From: Katie Herr
To: [Jessica Riches](#)
Subject: A/2/26/DOC
Sent: 28/01/2026 11:05:04

I am writing in relation to application A/2/26/DOC and the proposed planting mix for the bund. Having reviewed the species list, I would like to comment on its suitability for noise reduction and visual screening, as these are key functions of a bund in a new development.

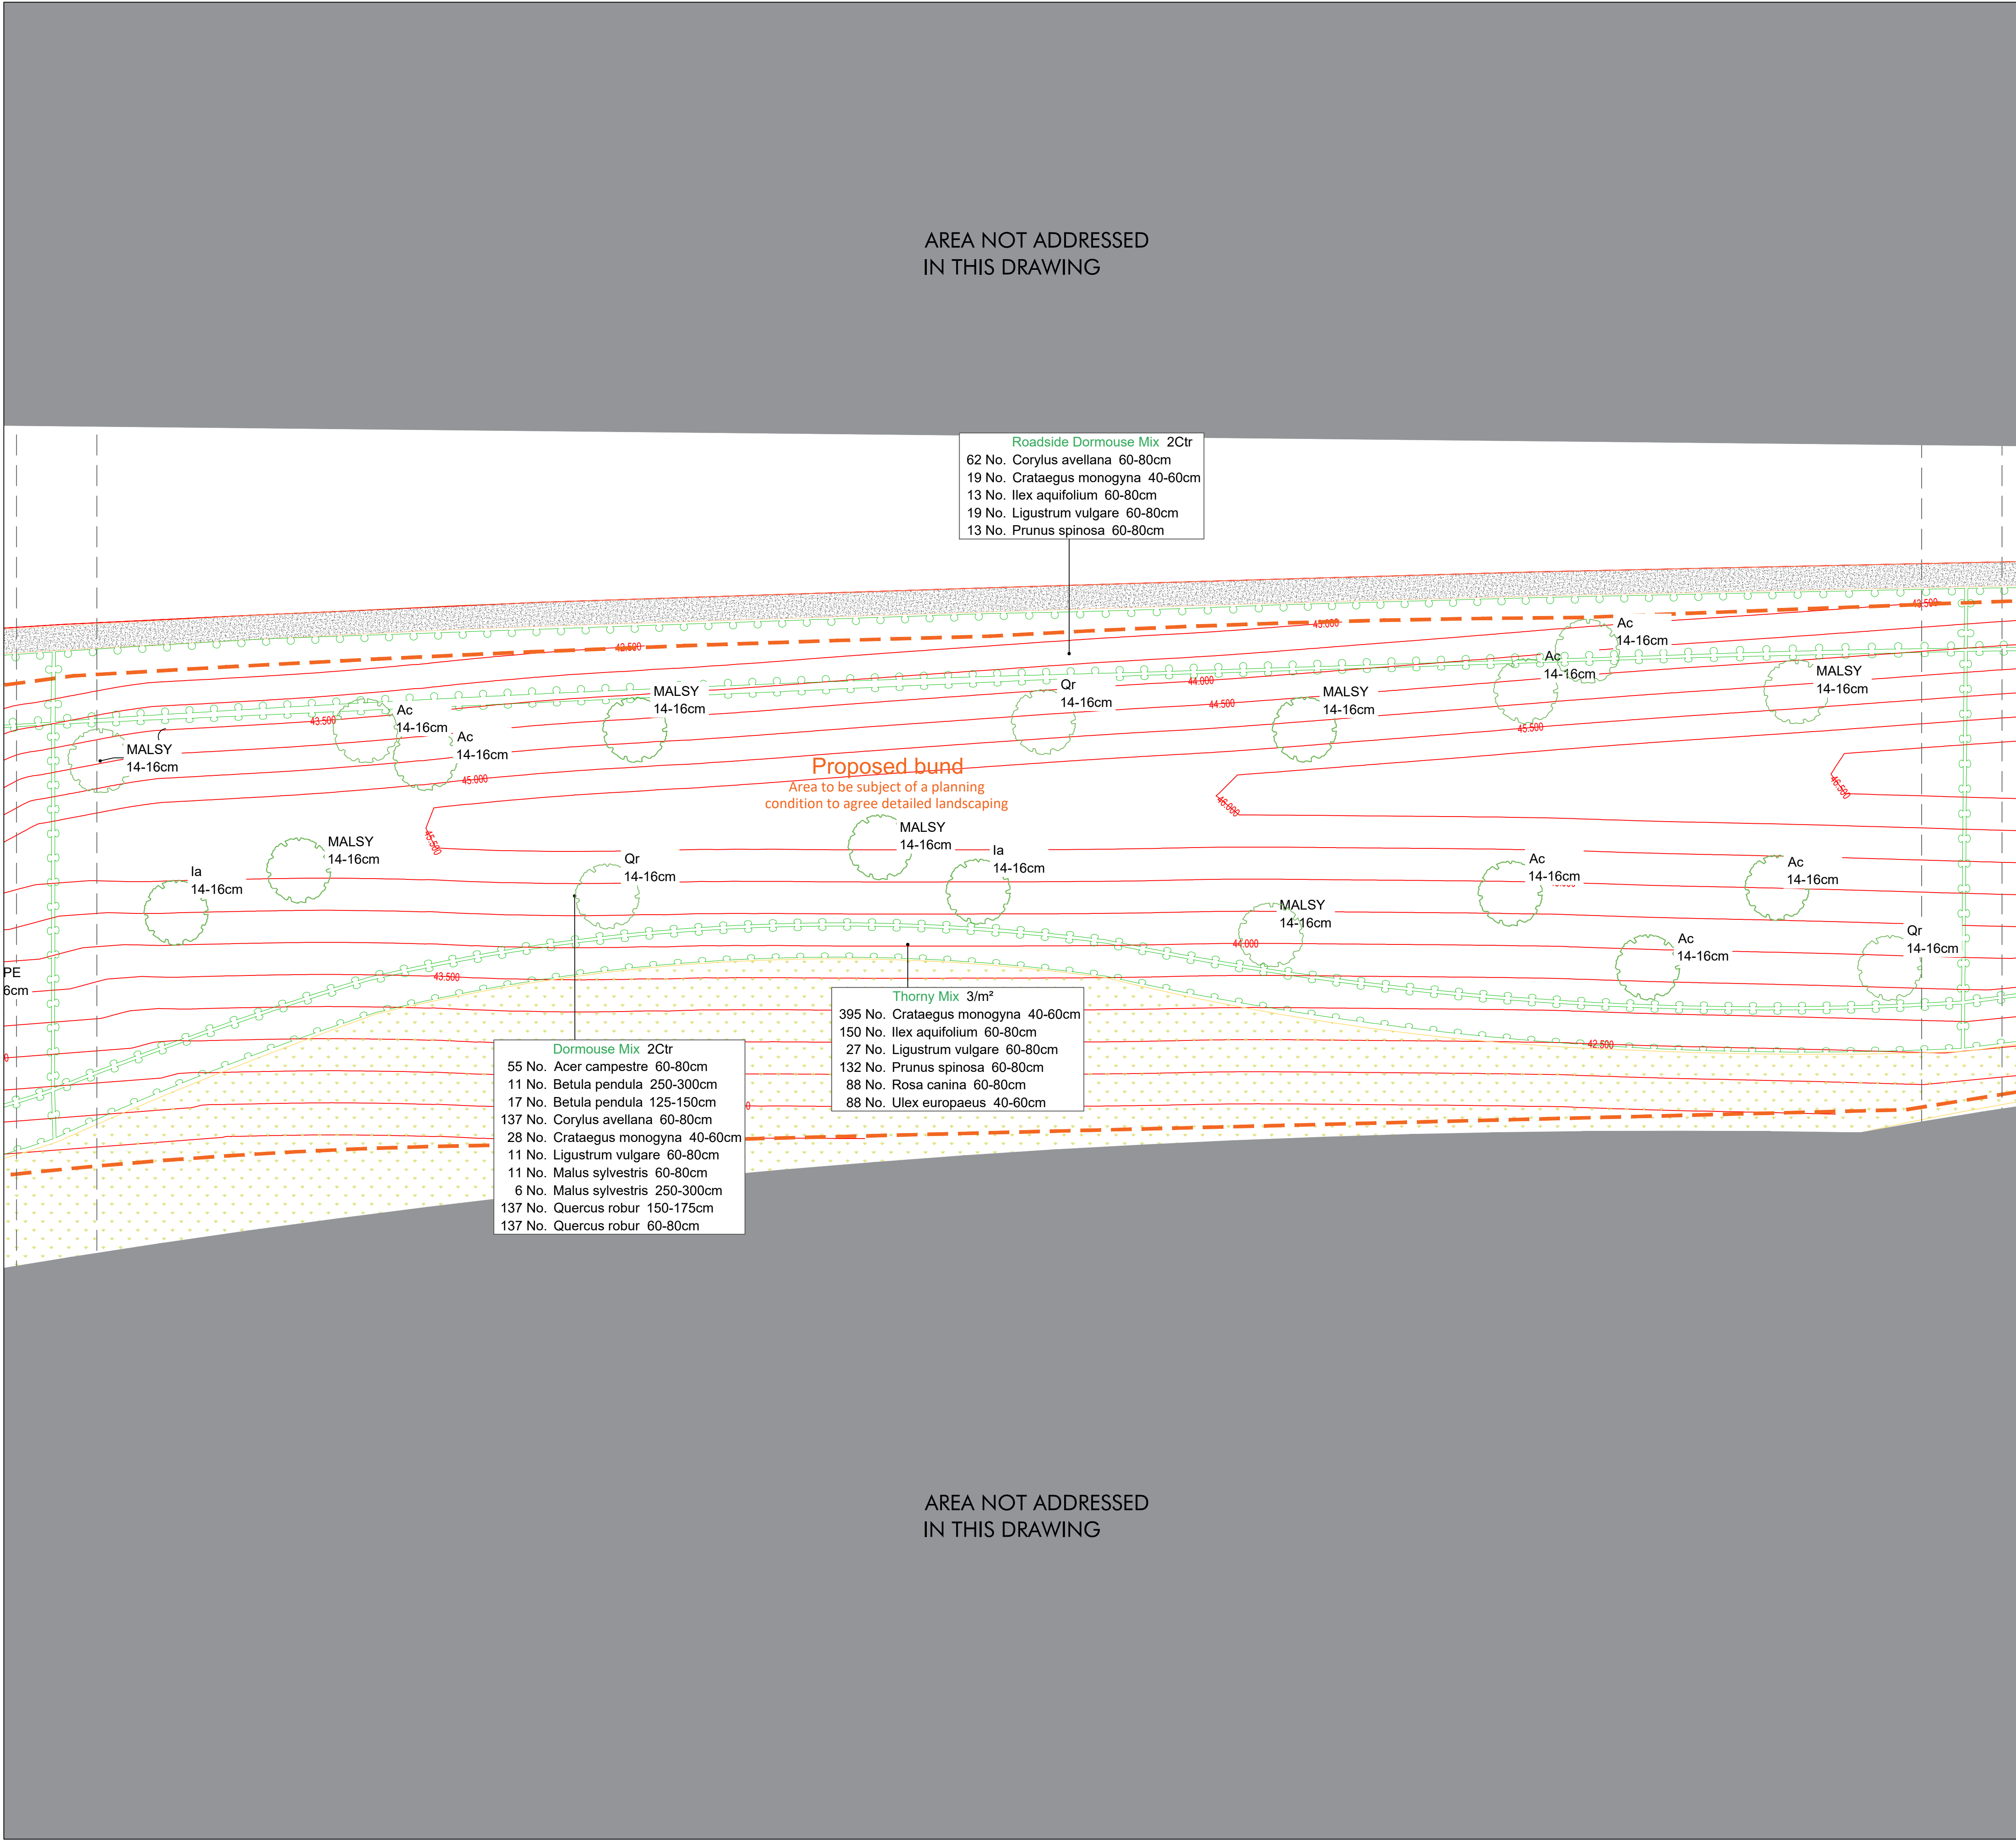
The proposed planting mix for this application is composed almost entirely of deciduous species, with holly (*Ilex aquifolium*) being the only evergreen included. While this mix provides strong ecological and hedgerow benefits, and offers some visual screening, it is not optimal for noise reduction, especially in winter when the majority of the planting loses foliage. Research confirms that evergreens maintain their sound-blocking performance year-round, whereas deciduous vegetation is significantly less effective outside the growing season.

While species such as oak (*Quercus robur*) offer some sound-scattering benefits due to their bark texture, and dense shrubs contribute to lower-level screening, the overall mix does not meet best-practice standards for acoustic planting. A bund intended for noise mitigation would normally include a proportion of tall, dense conifers to form a continuous evergreen barrier.

We therefore respectfully request that the planting scheme be reviewed or supplemented with appropriate evergreen conifer species to ensure the bund provides effective noise reduction and robust year-round visual screening, consistent with widely accepted landscape-planning guidance and noise-mitigation principles.
